Project:	National Highways Spatial Planning Arrangement 2021-2024	Job No:	60659714 / Q11DDO009.003
Subject:	Land at M40 J11: Transport Assessment, TA Addendum and DMRB Review		
Prepared by:	Wasiq Ruwaisdeen & Senth Sivanathan	Date:	18th November 2022
Checked by:	John Paul Hipkin & Kim Petingill	Date:	6th December 2022
Verified by:	Liz Judson	Date:	14th December 2022
Approved by:	Andrew Cuthbert	Date:	20th December 2022

AECOM have conducted a review, on behalf of National Highways (NH), of the Transport Assessment (TA), and a TA addendum prepared by David Tucker Associates (DTA), on behalf of Greystoke, prepared in support of a planning application for a proposed B8 development located at Land at M40 Junction 11, Oxfordshire. The TN will also undertake a DMRB Review of the proposed mitigation proposals at M40 J11. Following this review, AECOM make the following recommendations.

Based upon the ORDNANCE SURVEY MAPS with the permission of THE CONTROLLER OF HER MAJESTY'S STATIONERY OFFICE,  
 © Crown Copyright AL 100030412  
 © David Tucker Associates

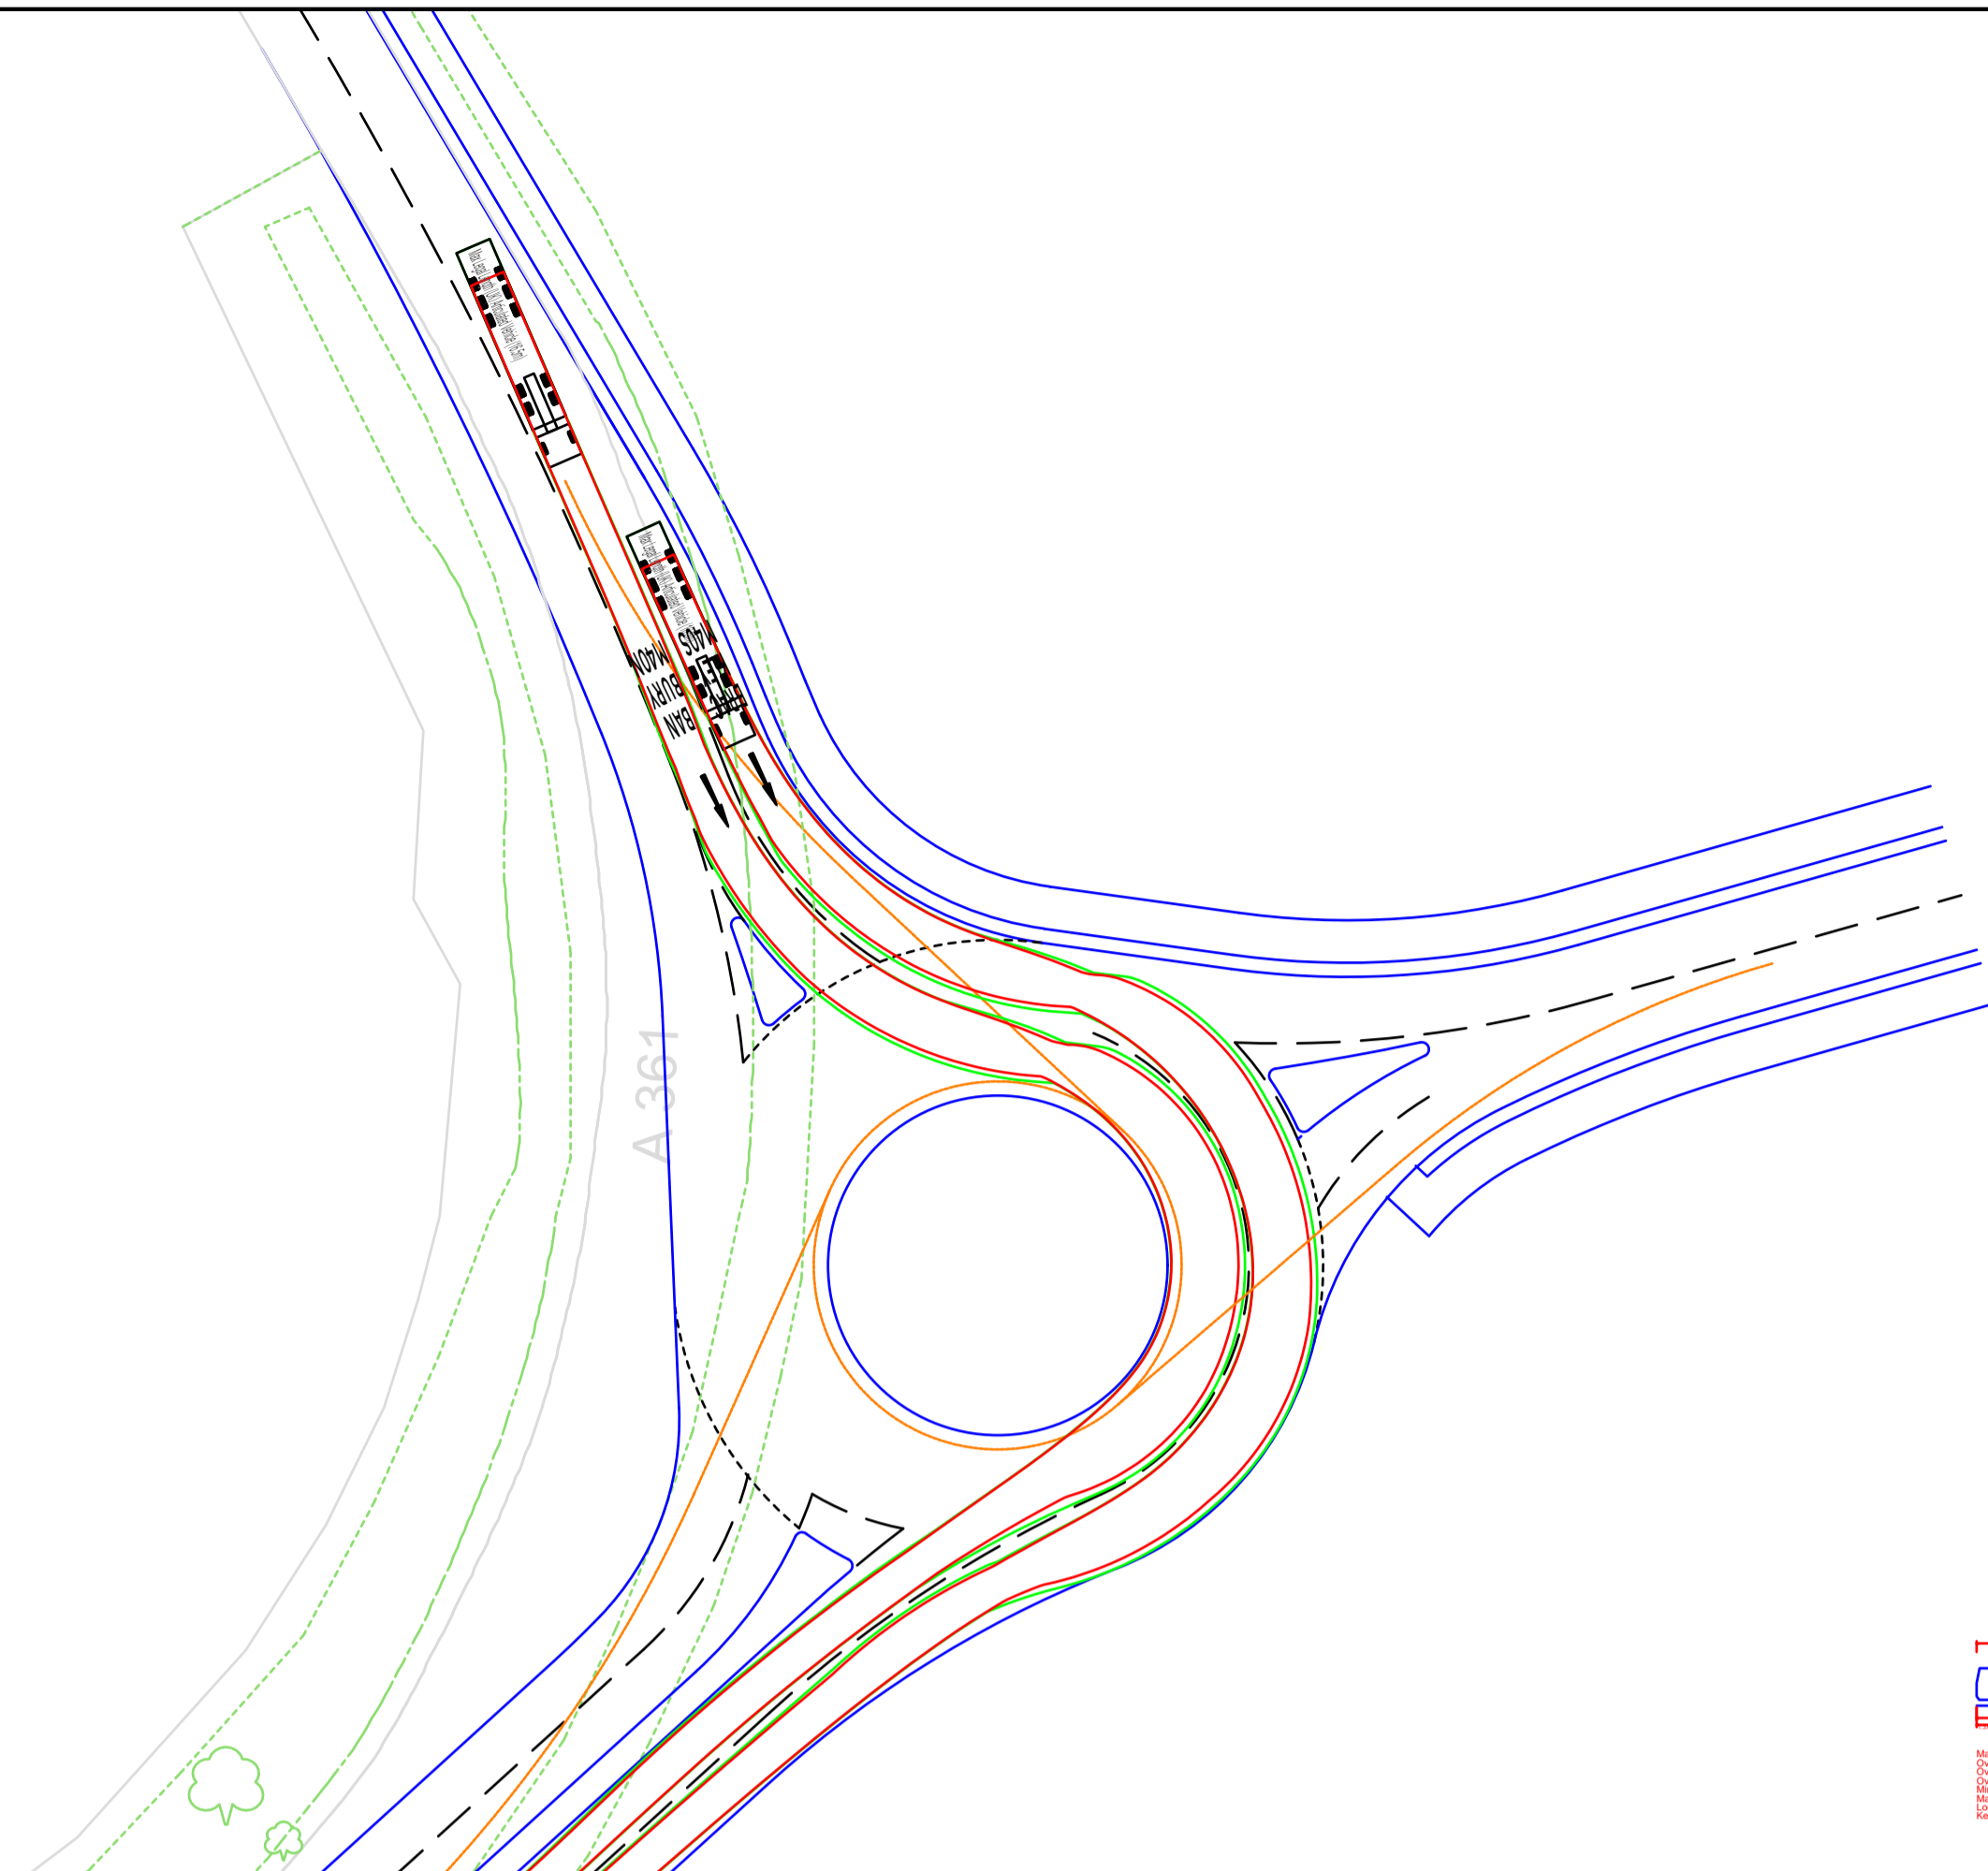
4. The reasoning behind HGV PCU factors should be provided. (Para 8.6)
5. With regard to the introduction of a short flare on the approach to the circulatory stop line on the westbound overbridge. The verge, earthworks and the 70m approach visibility to the signal heads should be clearly illustrated. The safety implications of felling mature trees so close to the edge of the Motorway should be taken into account in any construction management plan. (Para 11.16)

13. The visibility to the circulatory signal heads have not been illustrated on the drawing. There appears to be no reason why these visibility splays should not be achievable. It is recommended that these should be provided in accordance with CD 116 and illustrated on future revisions of the drawing. (Para 11.15)

14. With regard to the introduction of the short offside flare on the westbound overbridge. There is a concern that it may not be long enough to accommodate a full-sized HGV without the nearside rear corner of such a vehicle protruding into the middle lane and presenting a hazard to a car in the middle lane trying to get to the stop line. It is recommended this issue is addressed. (Para 11.17)

15. The proposed mitigation measures at M40 Junction 11 should be reviewed with regard to CD116, and illustrated/ annotated on an updated version of the drawing, to include:

- Entry kerb radius;
 - Entry angle;
 - Lane Widths/ Entry width/ Exit width; and
 - Entry path radius/ deflection. (Para 11.18)
16. Advice should be sought from the Safety, Engineering & Standards (SES) group within National Highways as to whether a Departure from Standards application would be required in respect of these existing features, if any of them are found to be substandard. (Para 11.19)

18. All primary signal heads should be shown to be located a minimum of 1m from the stop-line and the proposed locations for the secondary signal heads for the circulatory approach are illustrated on subsequent versions of the layout drawing and/or its successors in title. (Para 11.21)

19. The locations of the signal heads controlling the circulatory carriageway at the M40 northbound slip road entry should be illustrated on subsequent versions of the layout drawing and/or its successors in title and the visibility splay to the signal head shown. (Para 11.22)

20. The proposed locations for the traffic signal controller cabinets should be illustrated on subsequent versions of the layout drawing and/or its successors in title and that the controller cabinets are positioned accordance with TSM advice. (Para 11.23)

21. The intervisibility zone for the proposed signals should be illustrated on subsequent versions of the layout drawing and/or its successors in title. (Para 11.24)
